My comments - on the Written Submission on behalf of PEA by Bidwells, 6 July 2026 “Note on the Applicant’s Response to PEA’s Heritage Rebuttal (REP4-369)”

8.4.12.2 Response to ISH2 Action Point 27 – Masterplans, Appendix E: Aldham, Fordham and Fordstreet

Action Point 27: Colne Valley (north) – Draft Opportunities Plan

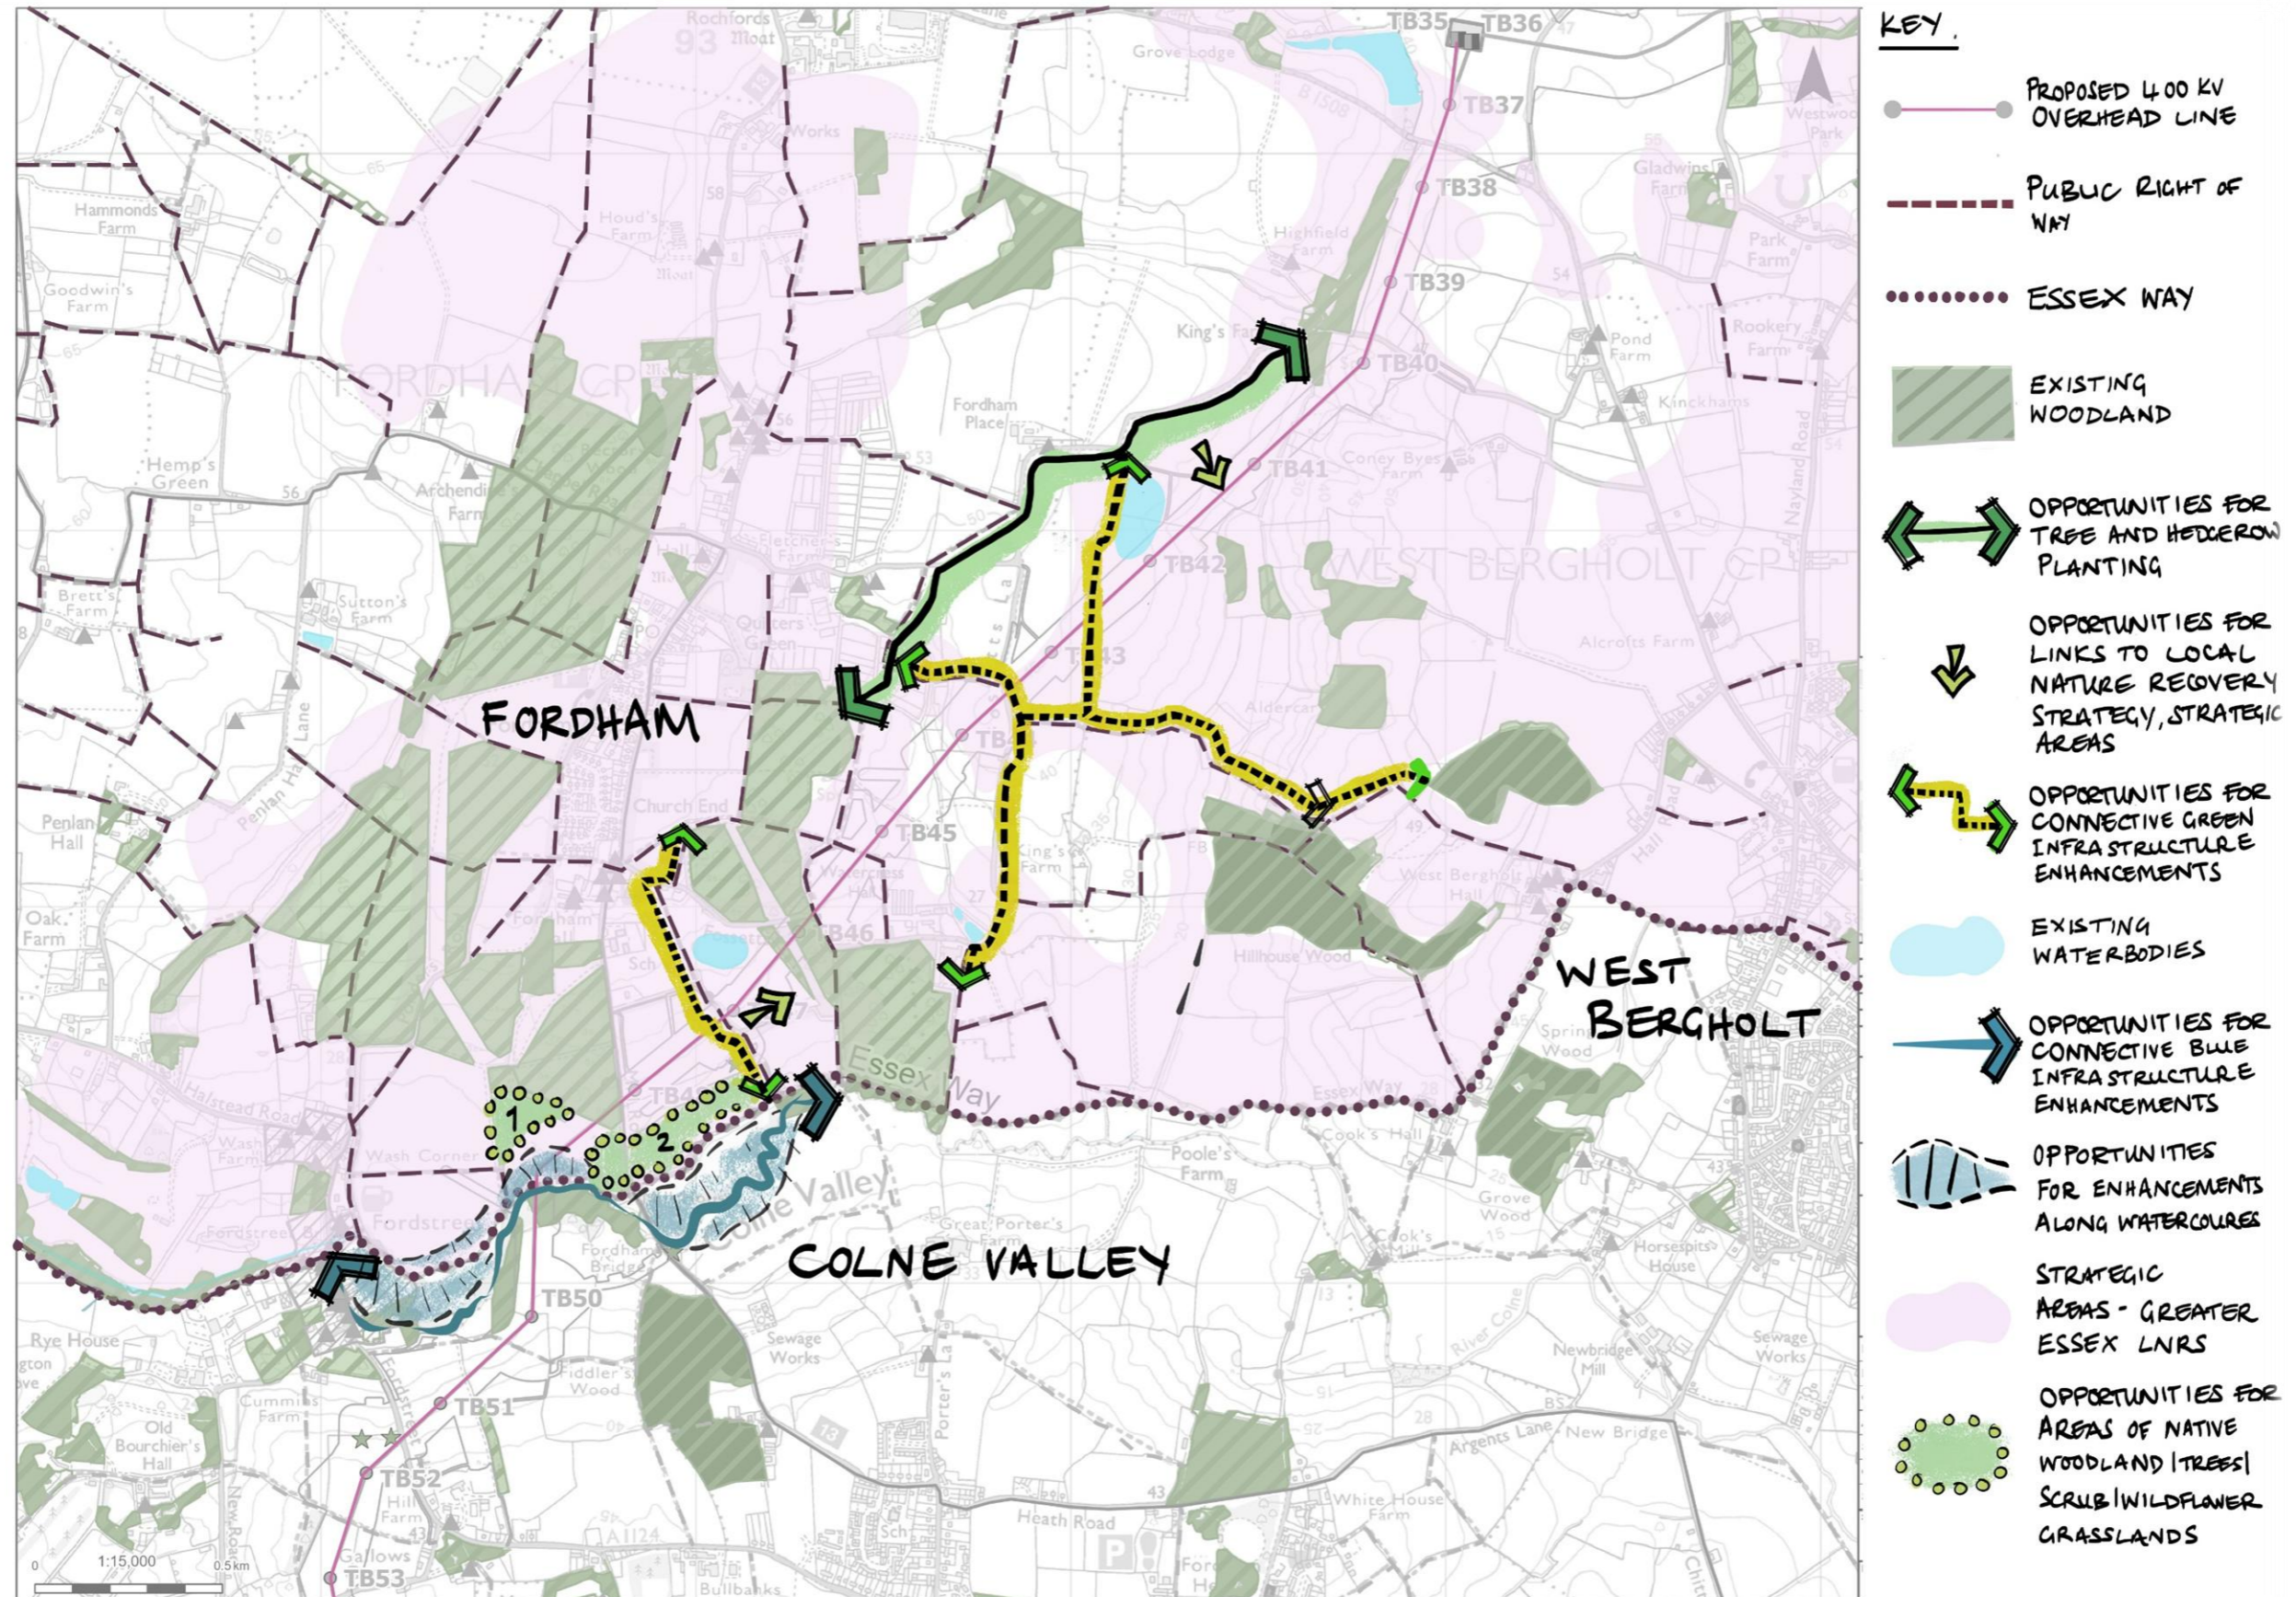
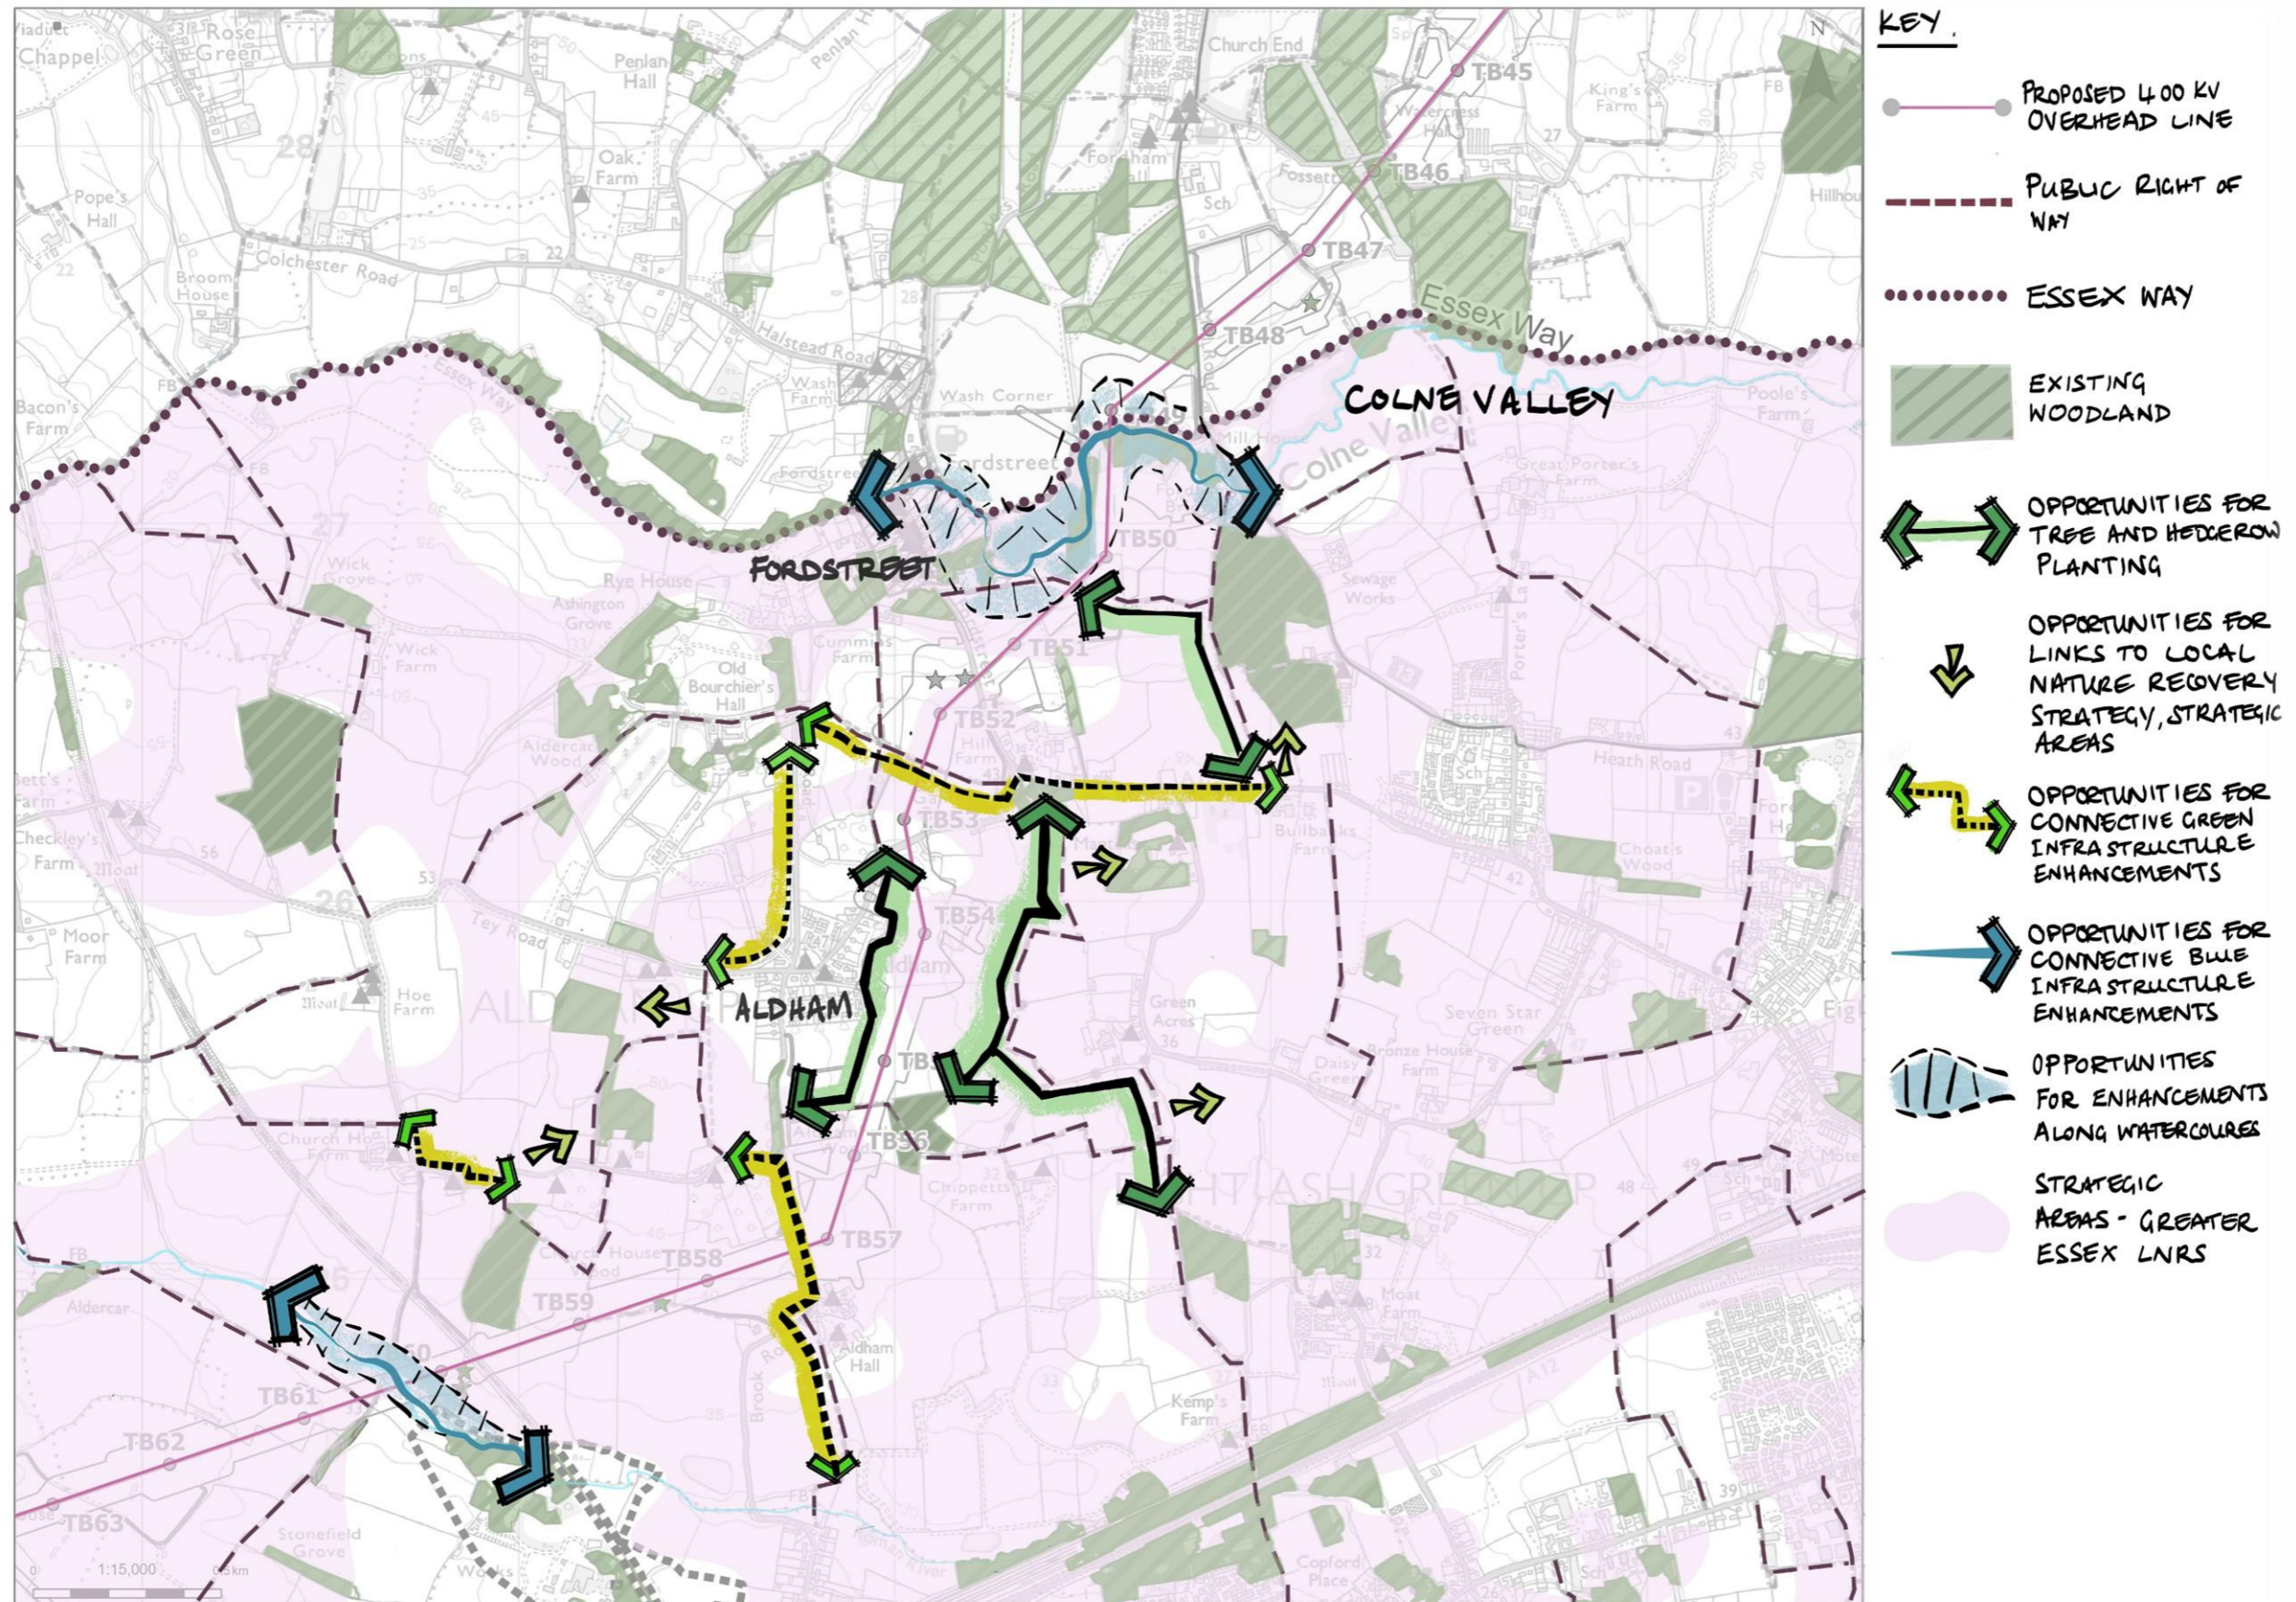
NG has provided limited sketch Opportunity Plans, not Masterplans. Neither Parish Councils nor local landowners have been consulted. The maps are vague and superficial, and many suggestions duplicate existing ecology – **see notes below***.

The two veteran trees at 21 on the Aldham Map are wrong. They should be at the bend in Tey Rd.

- * The area is already managed by the Woodland Trust for scrub and woodland
- NG proposes 'connective green infrastructure' on the Fordham Estate. The Woodland Trust already manages for habitat connectivity, meadowland, woodland, heritage, public access and recreation.

- The map fails to show the Roman River Corridor, which is shown in Colchester's Draft Local Plan as both an Essex LNRS nature opportunity and as green/blue infrastructure.

- The Local Nature Recovery Strategy also covers the Colne Valley maps, while NG employs irrelevant arrows.
- NG proposes part of Rectory Road, Aldham could see 'connective green infrastructure enhancements' but it is already a quiet country lane with mature hedgerows.

- They show that New Road, Aldham offers the same opportunity, but this road also already has mature trees and hedges all along it.
- They recommend tree planting where housing planning permission is granted.
